Beacon Fen Energy Park (Project Reference: EN010151)

Boston Borough Council's

Local Impact Report (LIR)

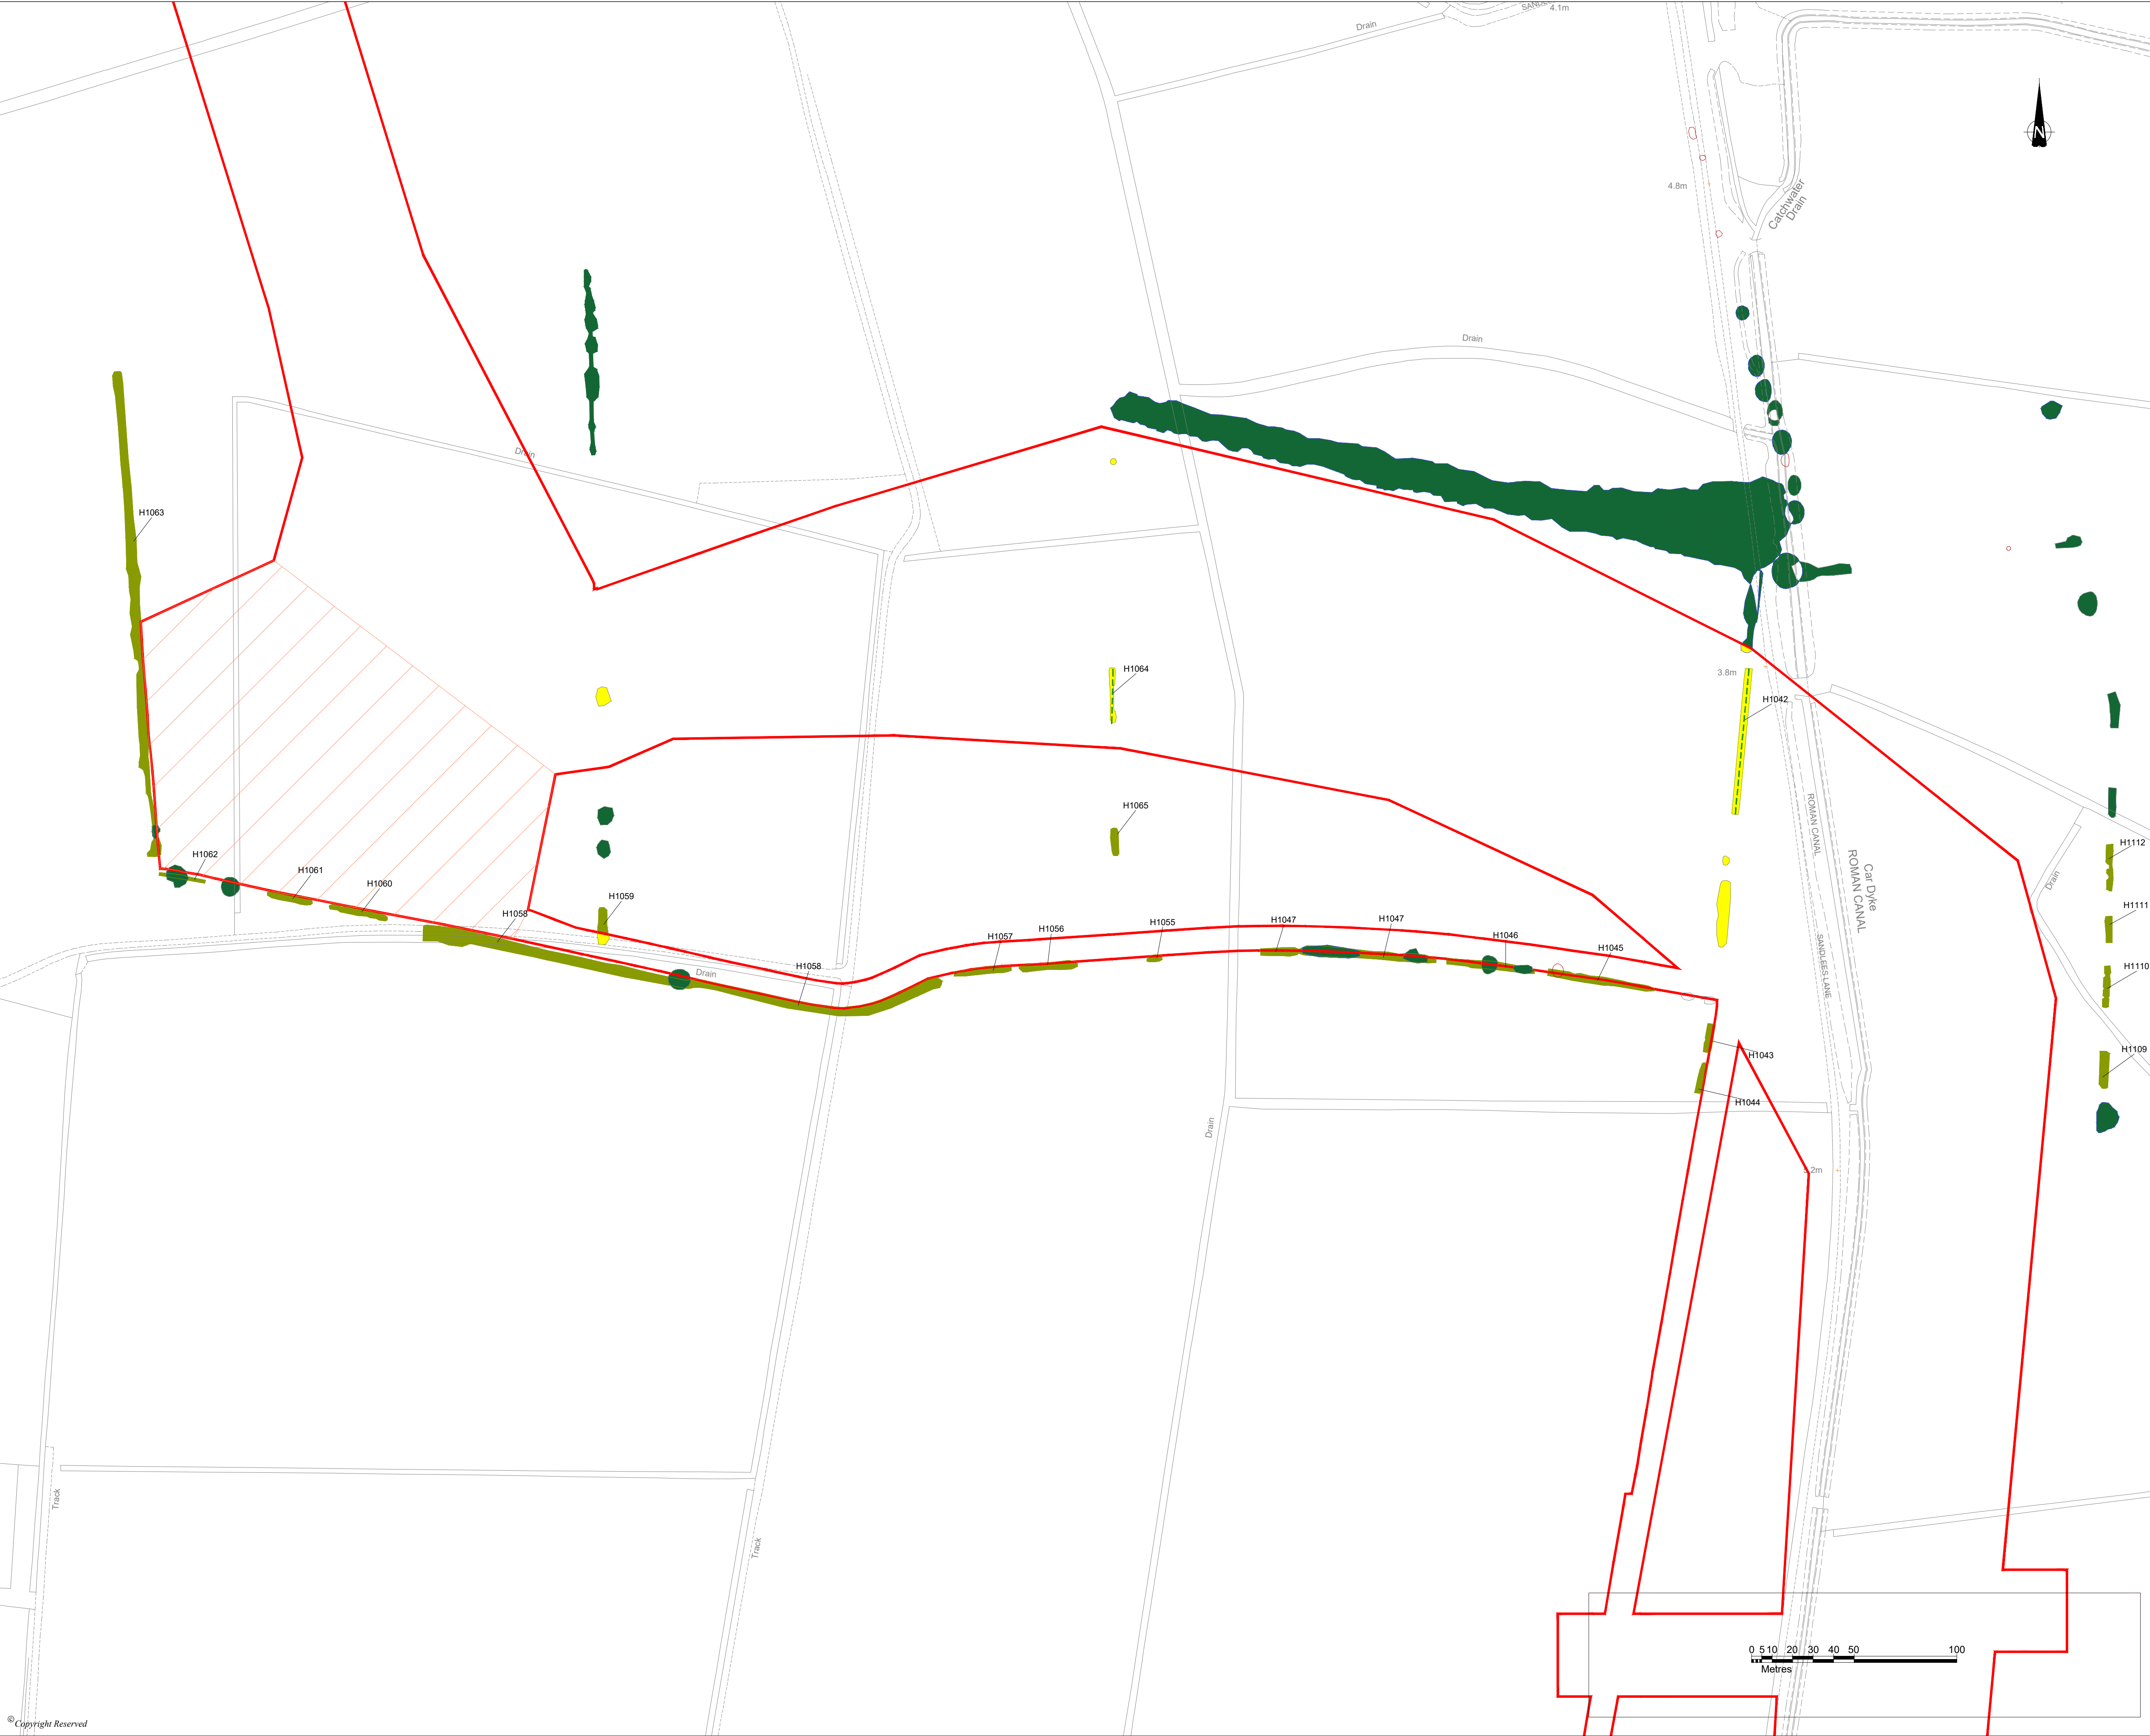
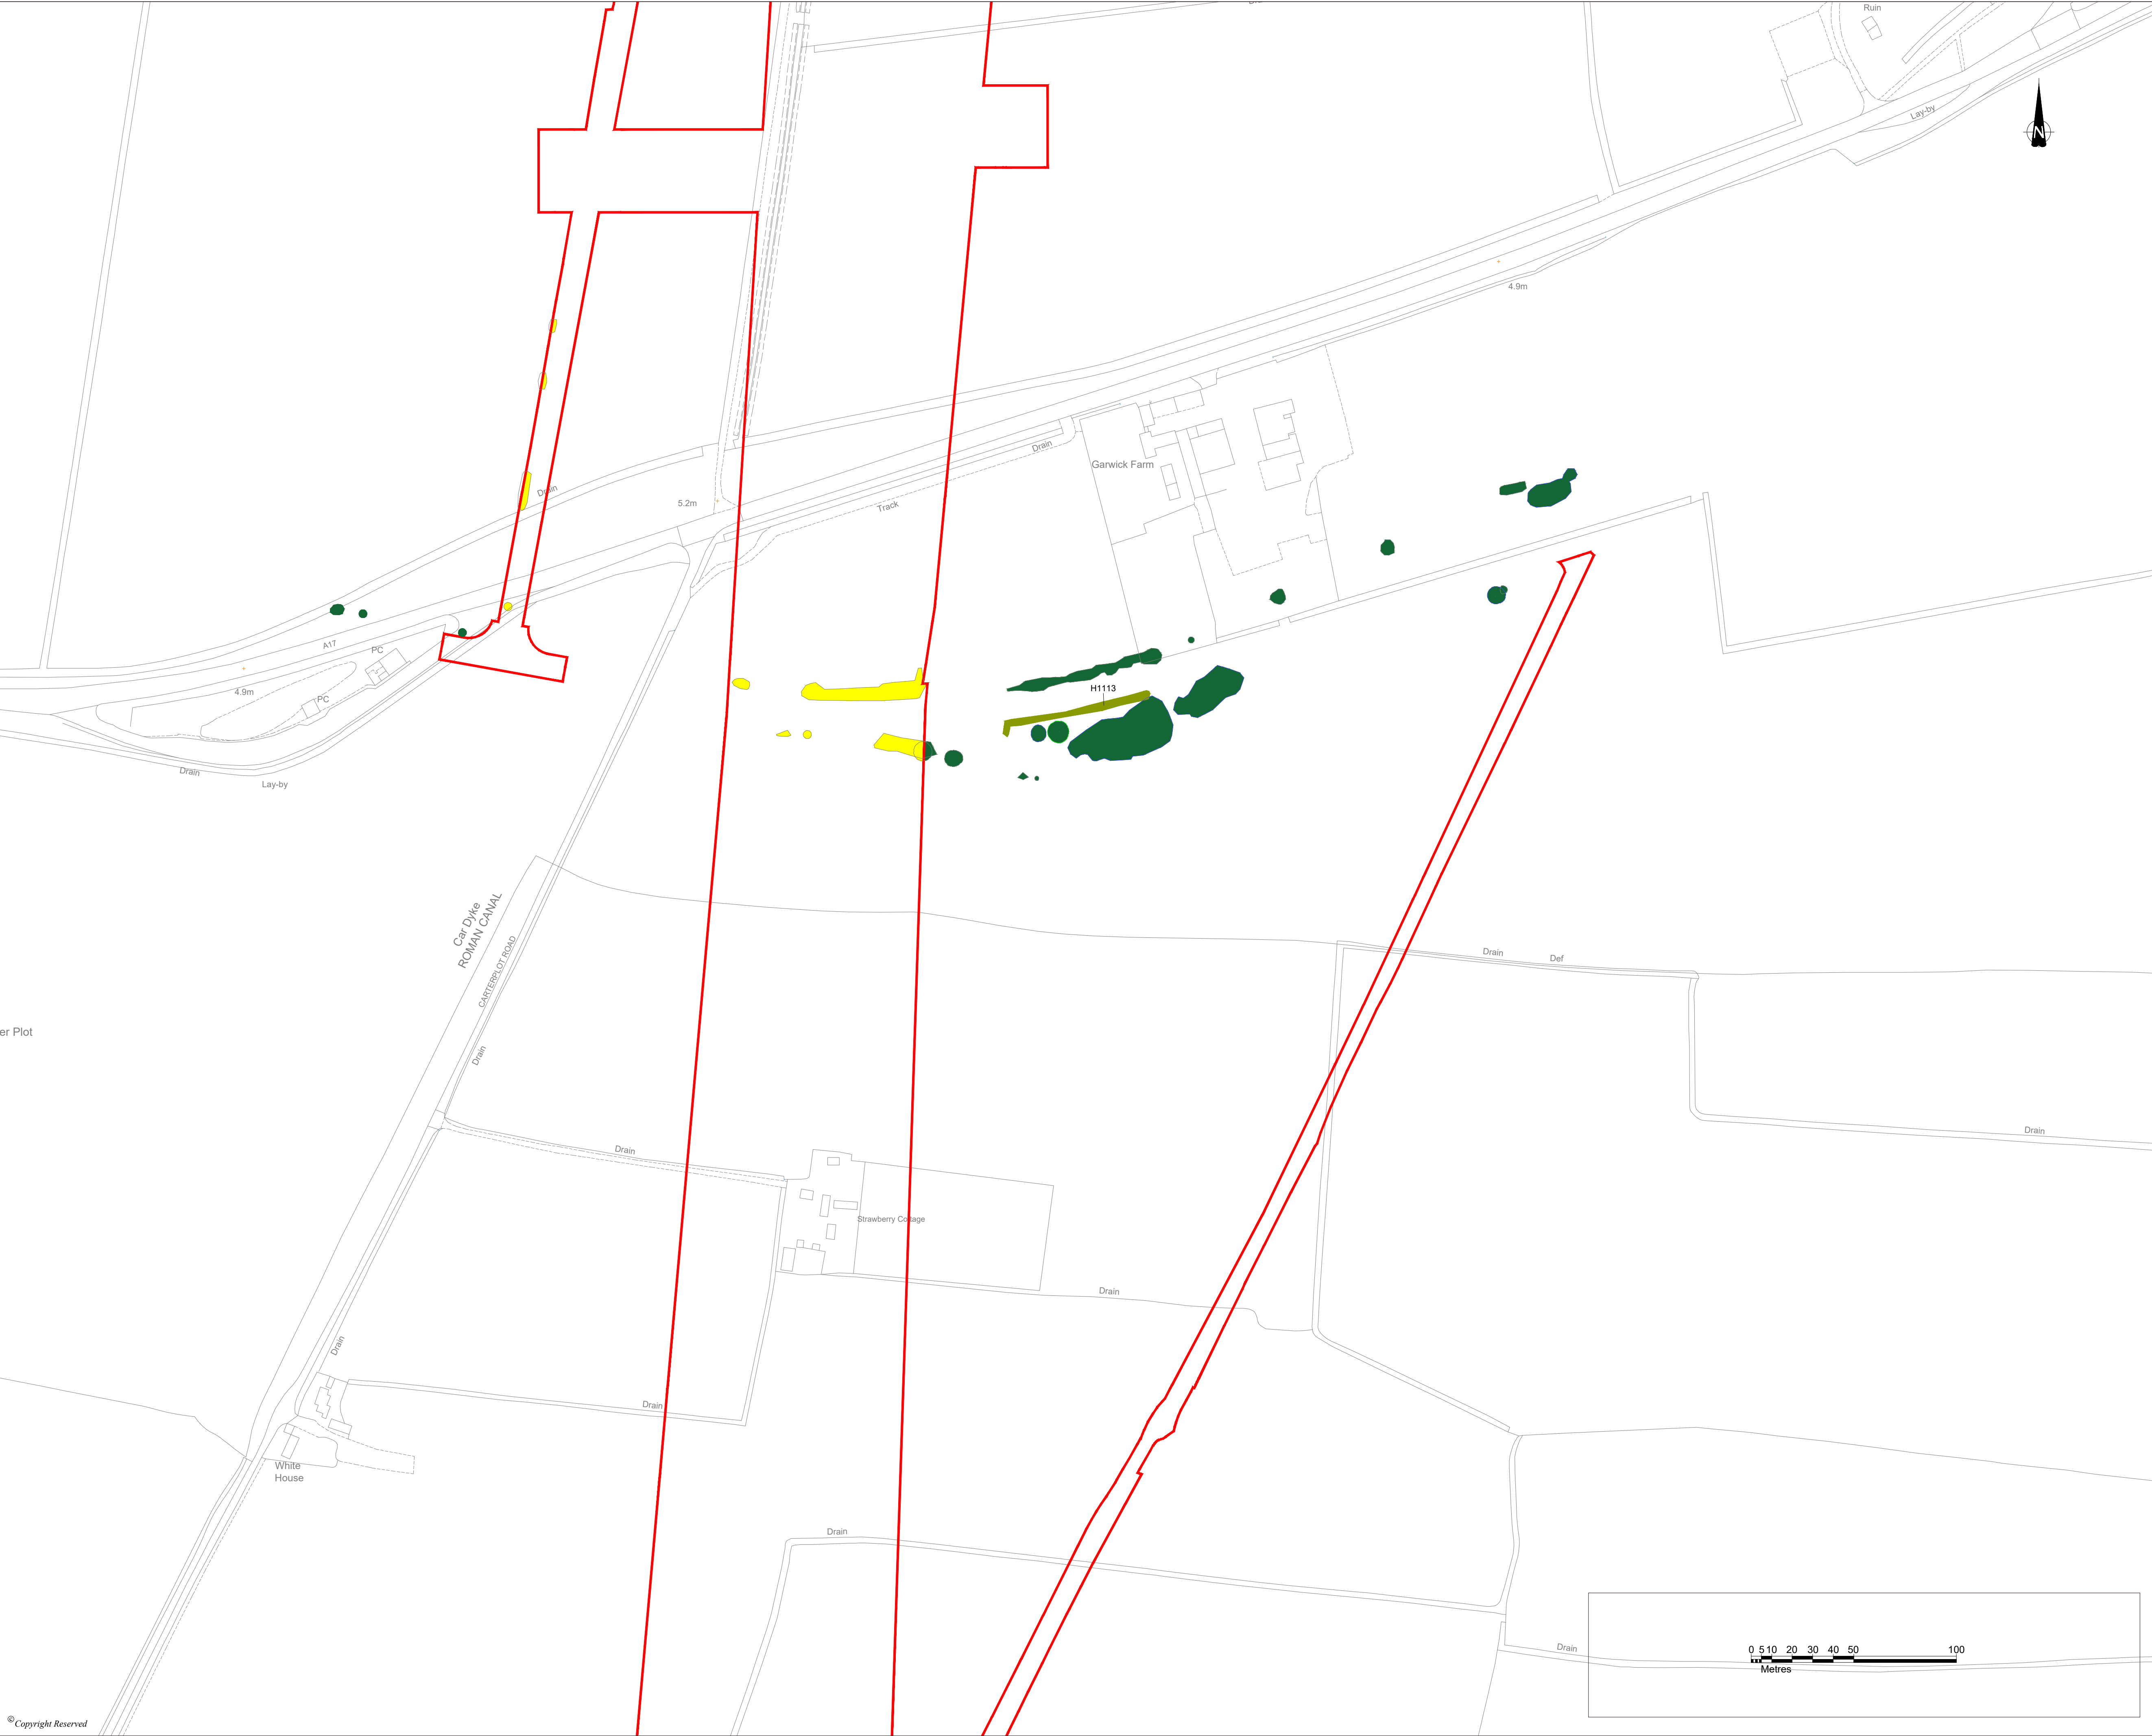
- Vegetation Removal at the extension to Bicker Fen Substation- Vegetation Removal Plan 6.4.43c Fig 6.32 doesn't clearly show the same vegetation removed as above. The Applicant should provide clarification on Vegetation Removal Plans for the extension to Bicker Fen Substation i.e. potential to remove all the vegetation within the Order Limits associated with the Bicker Substation.

- Vegetation Removal at South Forty Foot Drain a LWS -Vegetation Removal Plan 6.4.43c Fig 6.32 (APP-237) appears to show the removal of all vegetation within the LWS South Forty Foot Drain when HDD crossing is Proposed. The Applicant should provide Clarification on Vegetation Removal Plans for South Forty Foot Drain as the Borough Council are not why there is the need to show potential removal when the crossing method is committed as HDD trenchless crossing.

- 5.4.5 Vegetation Removal Plan 6.4.43c Fig 6.32 shows all vegetation removed (potentially) despite the crossing being confirmed as HDD. BBC are concerned that if there is potential to remove all the vegetation within the LWS then the Applicants confirmed use of the HDD trenchless crossing to cross the South Forty Foot Drain may not be as fixed as the ES suggests.
- 5.4.6 There is therefore concern that the Impact upon South Forty Foot Drain a Local Wildlife Site where the cable corridor crosses it particularly in regard to the potential loss of vegetation and clarity upon the crossing technique to be utilised is uncertain and maybe worse if all the vegetation was removed and the crossing technique changed.
